Jean Fraser - Re: 421 Warren Ave

From: Barbara Barhydt
To: Bushey, Stephen
Date: 2/20/2014 9:15 AM
Subject: Re: 421 Warren Ave
CC: Dobson, Lannie; Fraser, Jean; Schmuckal, Marge; Yeaton, Jennifer

I have to retract what I said before about distributing it. As I was preparing the Council note and notice, I realized I need to have the survey for the full site to show the division and the noticing for this project needs to be from the complete property boundary. We need the cbls for all the property under the same contiguous ownership. As I noted before the one lot split may not trigger subdivision review, but we need clarity on the 7 units as to whether those are rentals or condominiums. If this is not a subdivision, then Marge needs to confirm that the remaining lot meets zoning.

**BOUNDARY SURVEY**

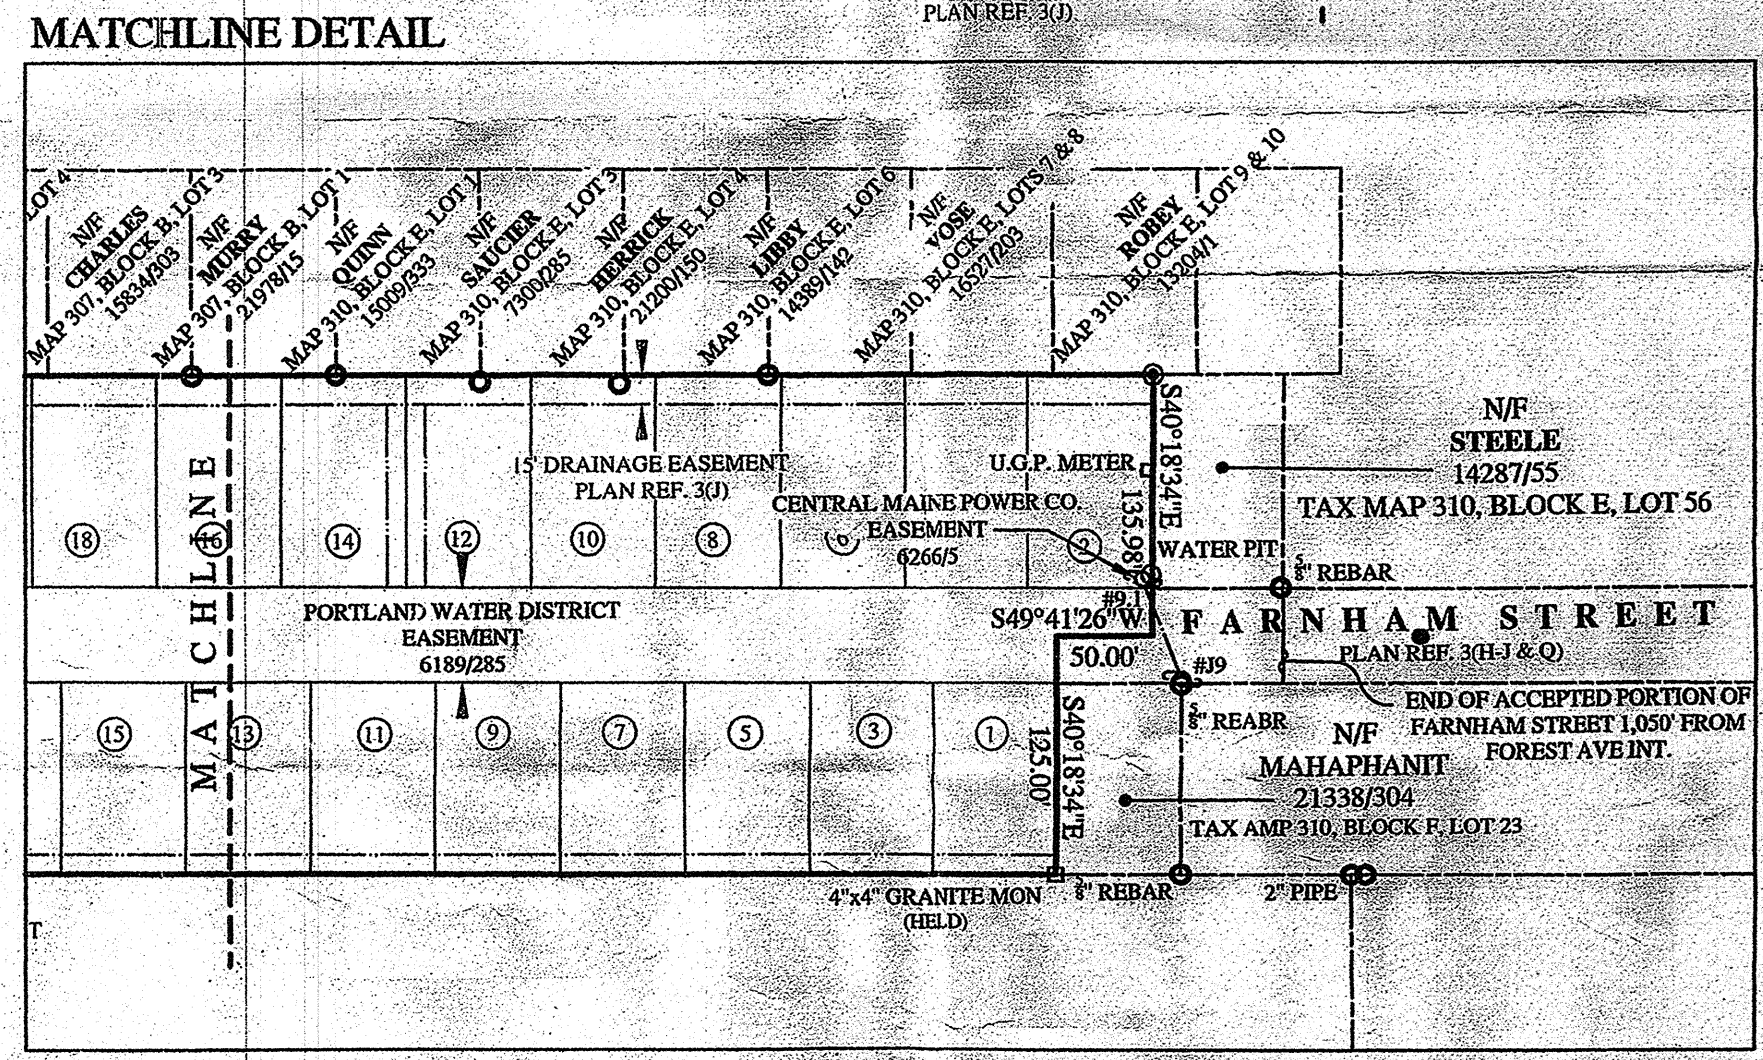
We do need to see the survey for the entire site. Marge needs to confirm that the remaining land meets zoning. In particular, does the site have adequate street frontage? Also, are the 7 units in the building condominiums or rental units? If it is just the one lot split, this may not require subdivision review.
